Application Ref:	3/2026/0476			 Ribble Valley Borough Council www.ribblevalley.gov.uk
Date Inspected:	26/8/26	Site Notice:	26/8/26	
Officer:	BT			
DELEGATED ITEM FILE REPORT:				REFUSAL

Development Description:	Proposed construction of one single-storey short-term holiday let.
Site Address/Location:	Land North of Woodpecker House, Sawley Old Brow, Sawley, BB7 4LF.

Drawing Title
Proposed Site Plan

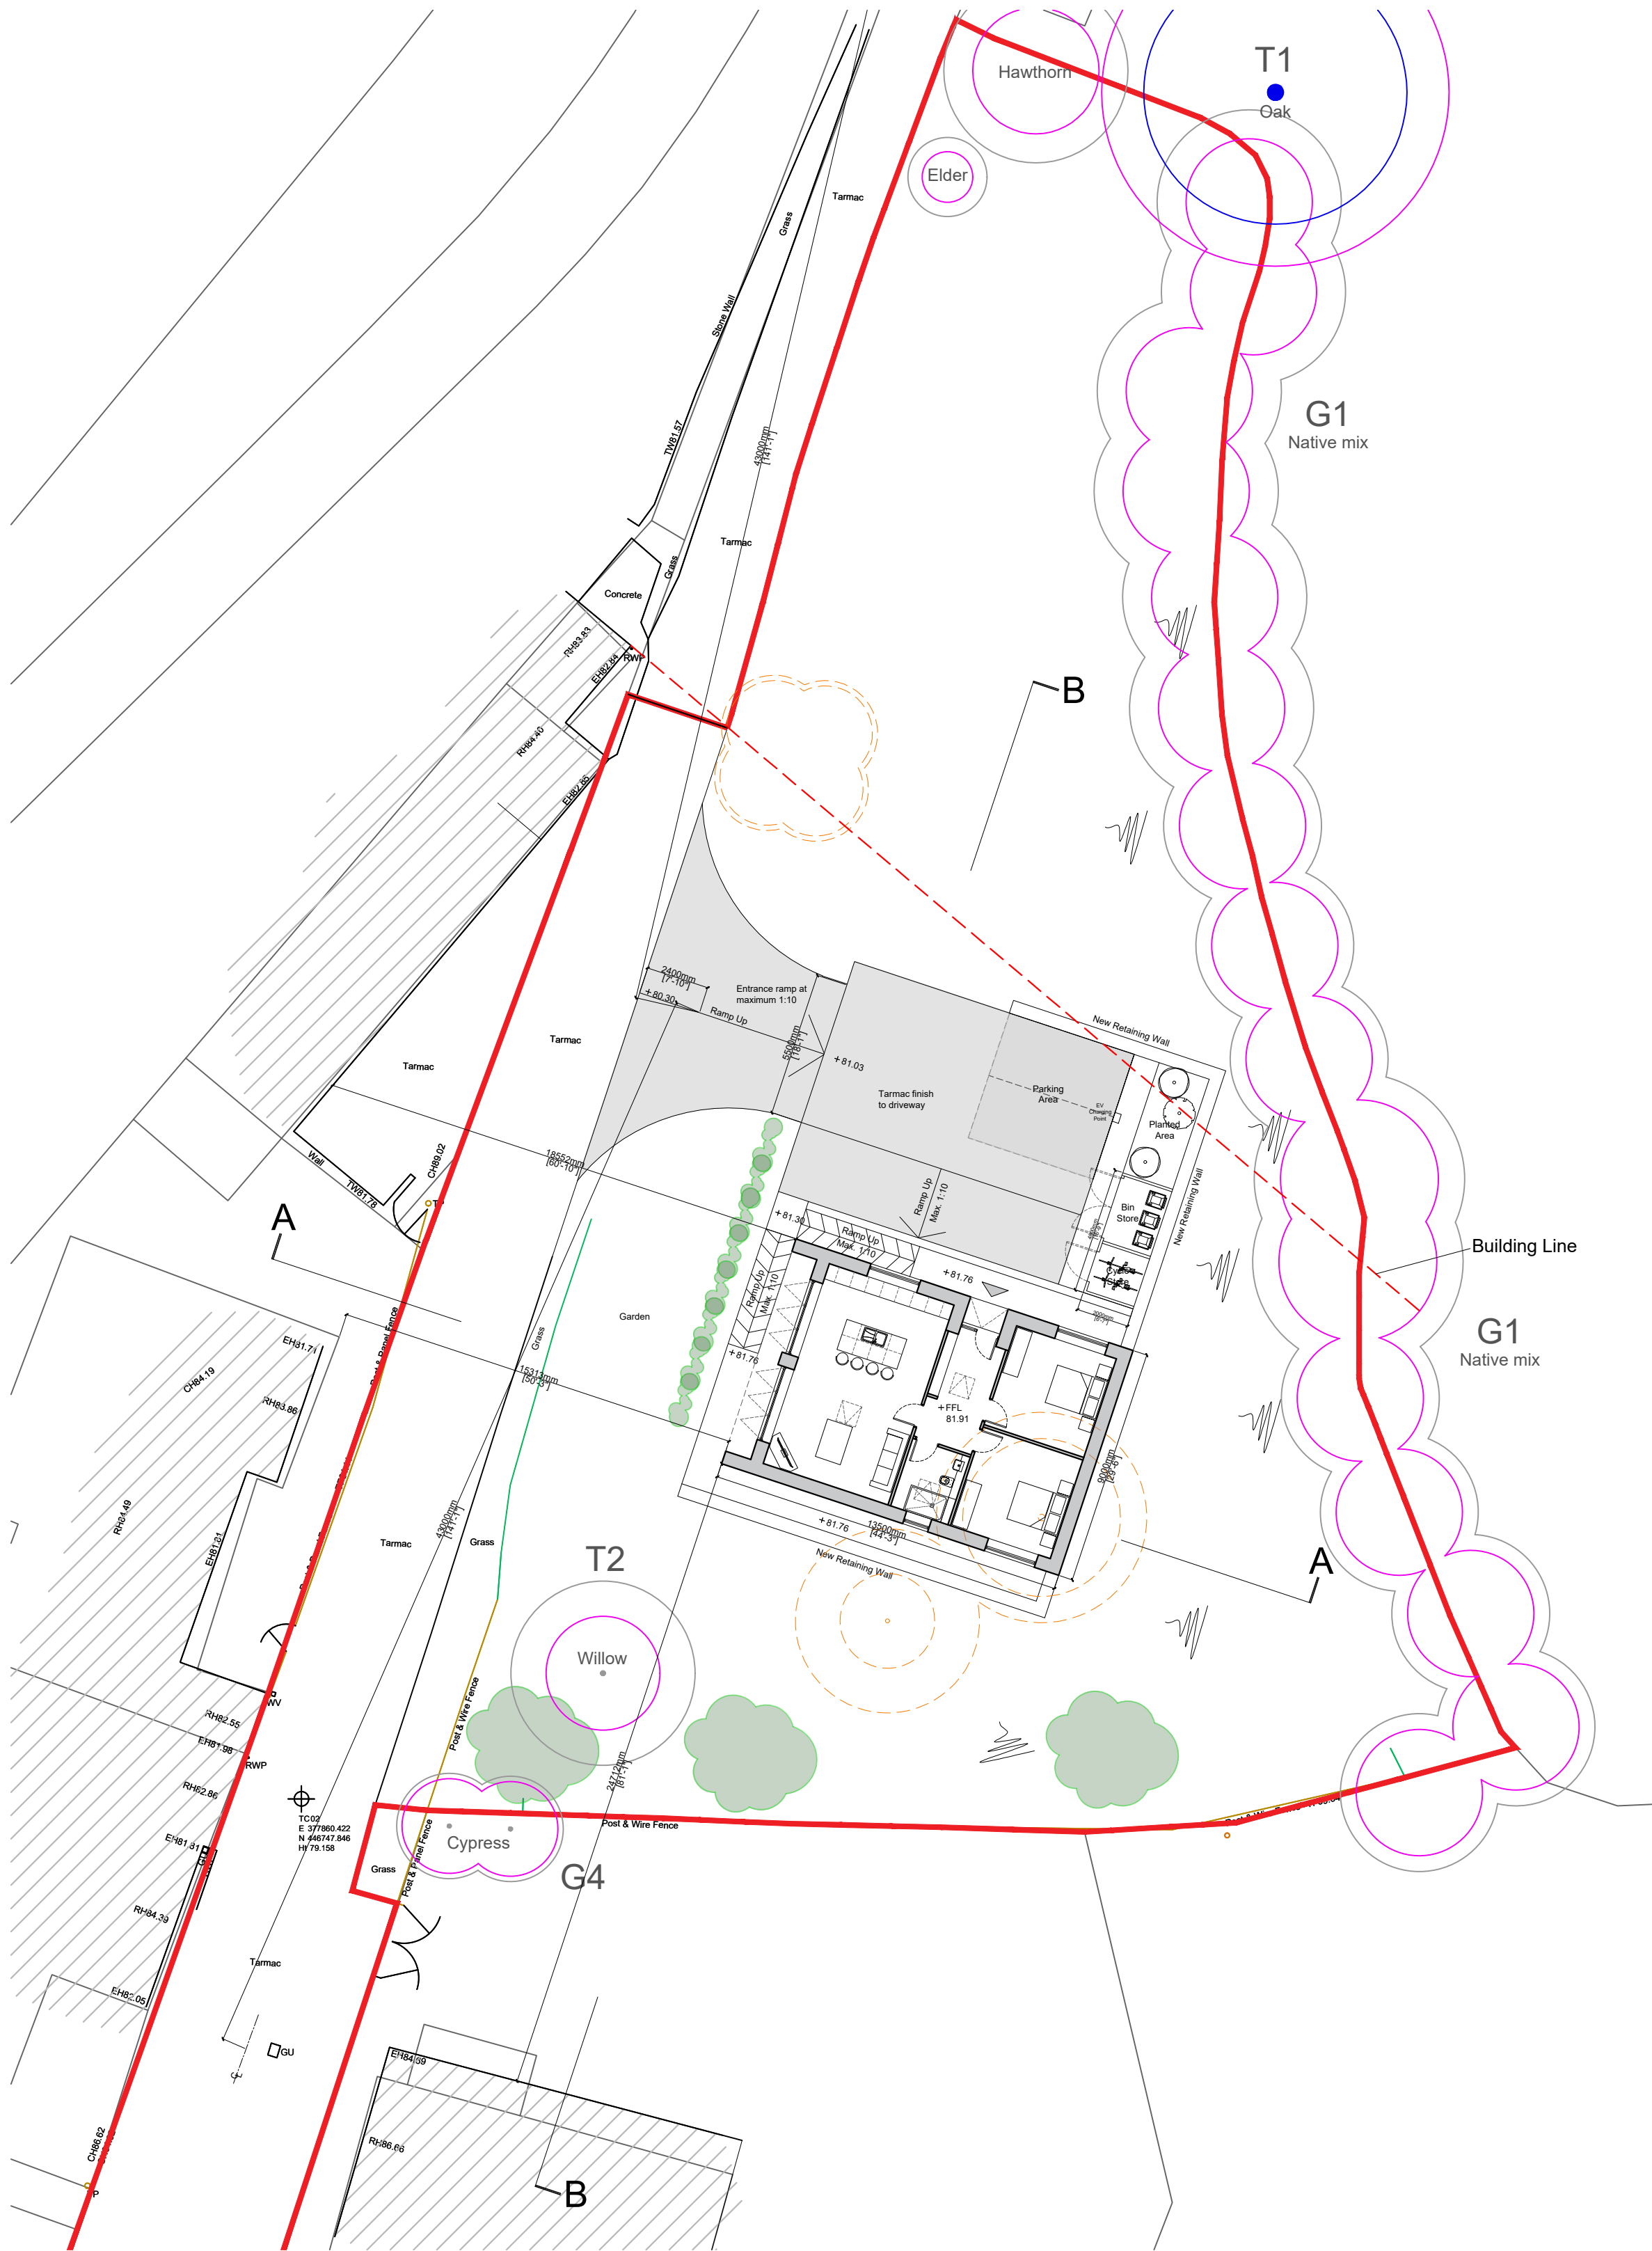
The proposed development would necessitate the creation of a sizeable hardstanding area within the centre of the site in order to accommodate the site's vehicle access, driveway and parking area. Additional hardstanding would also be required to accommodate the proposed holiday let in addition to a sizeable retaining wall feature. As such, a discernible portion of the site's natural features would be lost to the proposed development. It is noted that the proposal would incorporate replacement tree planting and soft landscaping however this would comprise a largely manicured appearance and as such would be largely at odds with the existing natural character of the site. In addition, a significant quantity of ground excavation would be required in order to level off the site which in turn would result in the loss of the site's naturally sloping topography which forms part of the wider moorland which ascends to the East of the site. Accordingly, all of the above works would result in a significant transformation of the existing site, with the site's natural and unspoilt character being largely engulfed by the resultant development. Whilst it is noted that a single unit of holiday let accommodation is now proposed (compared with previous proposal 3/2024/0672 which proposed two units), the proposal would nonetheless result in the introduction of the same harmful urbanising features which would cumulatively still carry a harmful visual impact.

Whilst it is acknowledged that built form exists within the immediate vicinity of the proposal site, the proposed development would nonetheless extend the existing extent of built form on unadopted track X1670 further Northwards through introducing the proposed holiday let and its associated hardstanding, garden area and domestic paraphernalia into currently undeveloped land which in turn would have an urbanising impact on the visual amenities of the area. In addition, the proposed holiday let would incorporate large glazed openings within its North-western elevation which would be predominantly at odds with the more traditional fenestration within the dwellings to the South-west of the site. Furthermore, analysis shows a predominant absence of microgeneration equipment on properties within the immediate area therefore the solar panels proposed for the holiday let would read as equally incongruous features that would have a further urbanising impact upon the area. The application's supporting statement makes reference to the presence of glazed gable features and microgeneration equipment within the vicinity of the proposal site as a means of justifying the design components of the proposal however these were added as supplementary features to domestic properties in an existing residential setting and as such are not considered to be comparable to the development being proposed under this application as a means of justifying a visually incongruous form of development.

Moreover, the proposed development would be publicly viewable in close range views from unadopted track X1670 and Public Right Of Way BW0339016. Analysis shows that the resultant development would also be visible in long range views from the East from Public Right Of Way FP0339007 and Smalden Lane. As such, the proposed development would have a discernible visual impact within the surrounding landscape.

In light of the above, it is considered that the proposal would constitute an inappropriate form of development in as much that the cumulative visual impact of the holiday let, microregeneration equipment, hardstanding areas, garden area, retaining wall feature and associated domestic paraphernalia would collectively have a harmful urbanising impact upon the surrounding National Landscape that would neither enhance or conserve the visual amenities of the immediate or wider landscape. The proposal would therefore fail to satisfy the requirements of Policies DP3 (1) and NPPF N4 (1) of the NPPF and Key Statement EN2 and Policies DMG1 and DME5 of the Core Strategy.

Drawing Title
Proposed Floor Plans, Elevations and
Site Sections

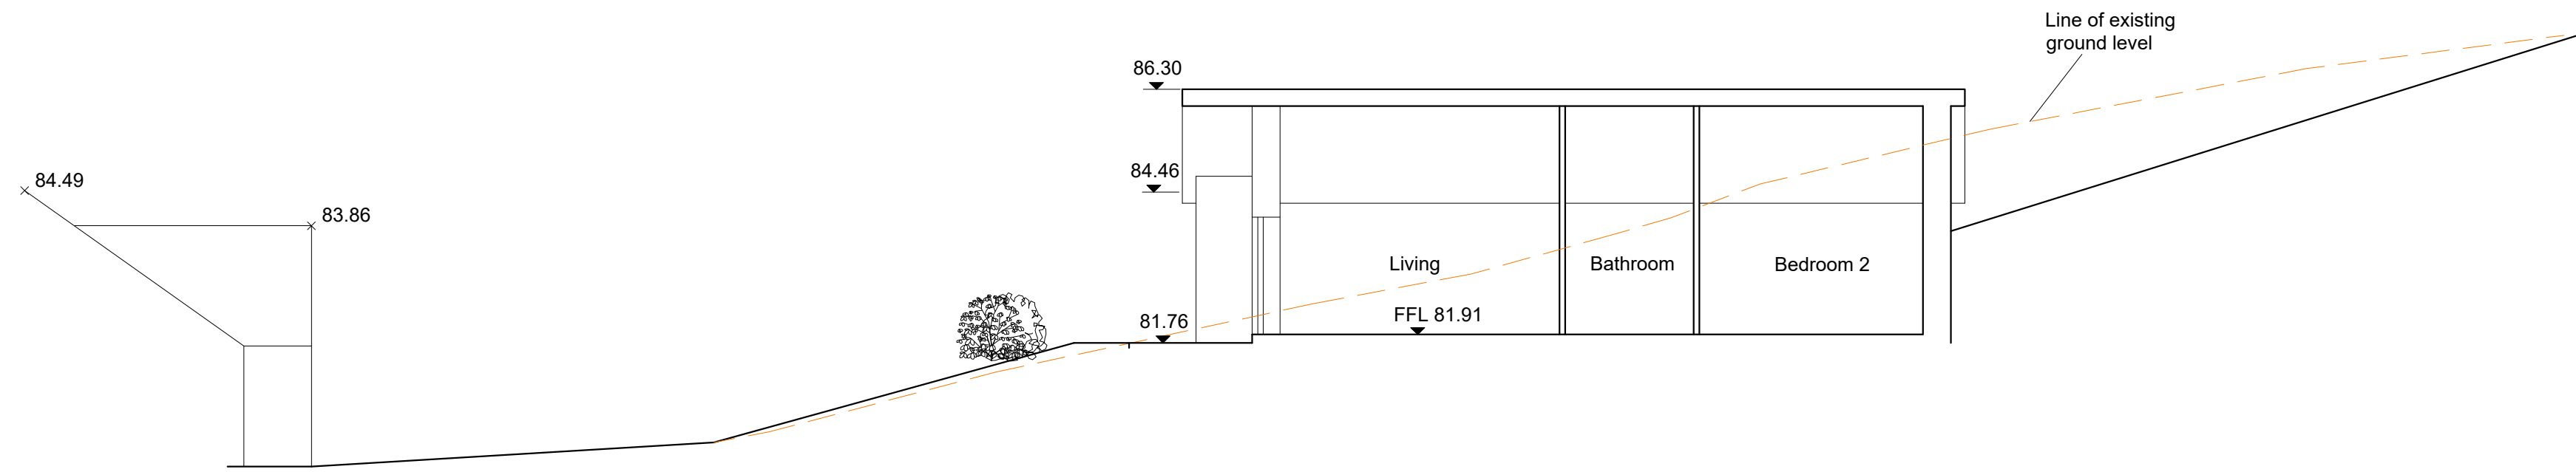
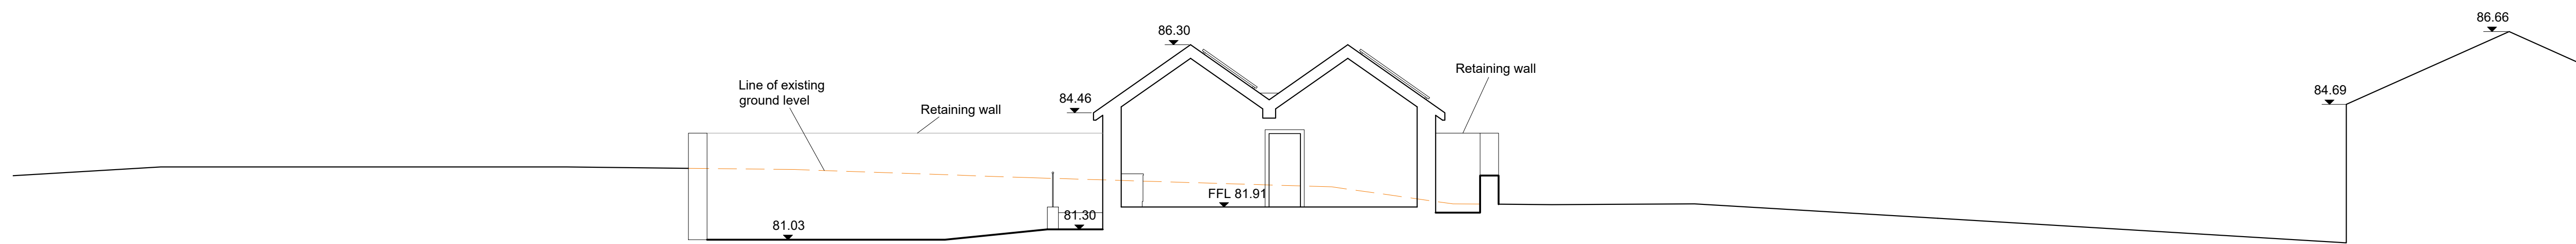
In this instance, the South-eastern facing elevation of the proposed holiday let would contain a window serving a bedroom which would face towards the adjacent neighbouring receptor of Woodpecker House however a separation distance of approximately 25 metres would be in place between the holiday let and Woodpecker House which would allow adequate privacy levels to be maintained. In addition, the large majority of the bedroom window within the holiday let would be screened by a retaining wall feature. Furthermore, a sufficient separation distance would be in place between the proposed holiday let and neighbouring receptor of Ribble Dene. Consequently, given the separation distances that would be in place, no concerns are raised with respect to loss of privacy, outlook or natural light to the proposal site's immediate residential receptors.
